STATE OF NORTH CAROLINA
DEPARTMENT OF TRANSPORTATION

Addendum No. 1

RE: Contract # C204229

1 SECTION OF NC-24, 1 SECTION OF NC-41, 1 SECTION OF NC-411
AND 8 SECTIONS OF SECONDARY ROADS.

| PAVEMENT SCHEDULE | | | | | |
|-------------------|------------|----|---------------------------|----|-------------------|
| C3 | 1½" S9.5B | F1 | MAT COAT #6 STONE GRANITE | V3 | MILLING 2" DEPTH |

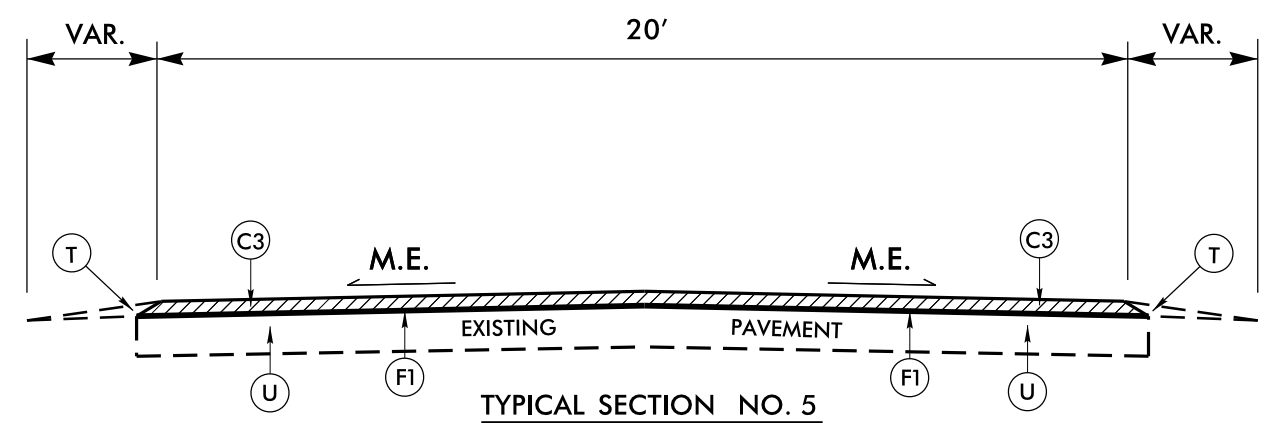
Sheet No.	Revisions
4	In the Pavement Schedule, F1 has been revised to Asphalt Surface Treatment – Mat Coat #67 Stone (Granite)
5	In the Pavement Schedule, F1 has been revised to Asphalt Surface Treatment – Mat Coat #67 Stone (Granite)
6	In the Pavement Schedule, F1 has been revised to Asphalt Surface Treatment – Mat Coat #67 Stone (Granite)
10	AST Matcoat column revised to #67 Stone
10	Quantities in Emulsion for AST column revised (See quantity revision below)
